**Consultation Response from KC,
Highways Development Management**

2026/90694 26-28, Mill Lane, Hanging Heaton, Batley, WF17 6LE

Use of land for siting of storage container

Date Responded: 18/08/2026

Proposed Ground Floor Plan

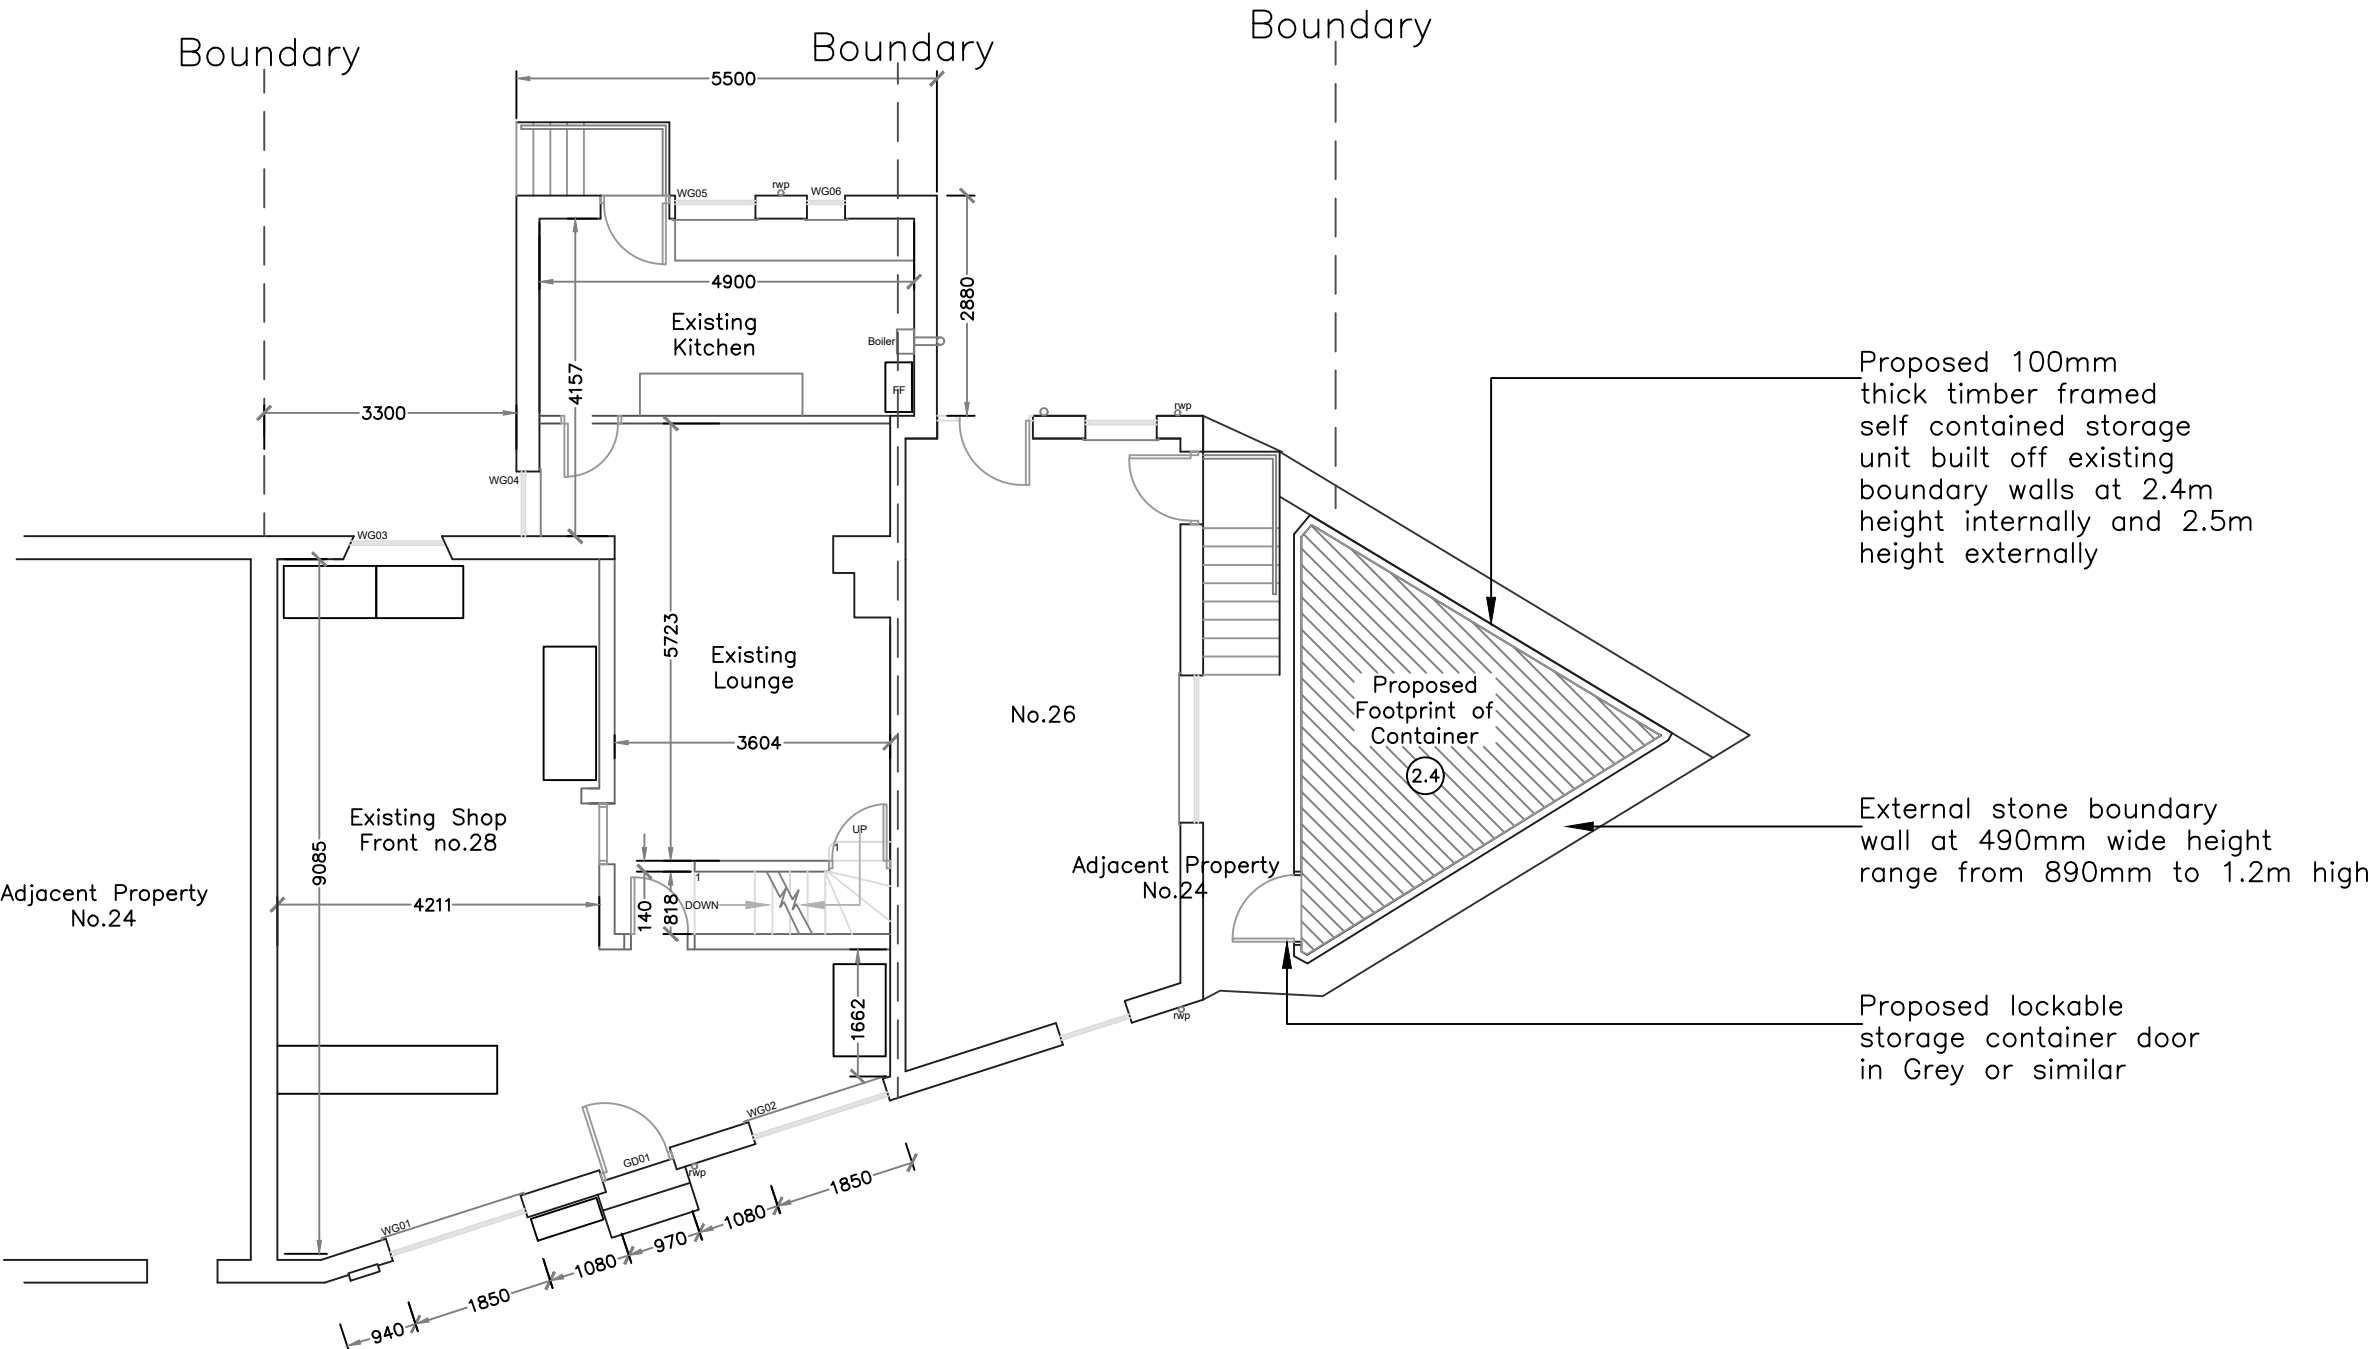
Access arrangements to the site remain unchanged. The container can be accessed internally within the site boundary and does not interfere with existing pedestrian or vehicular access arrangements.

As a result. Highways Development Management have no objection to these proposals.

The proposed container would be required to be ancillary to the commercial premises for the lifetime of the development and the site not sold on the open market.
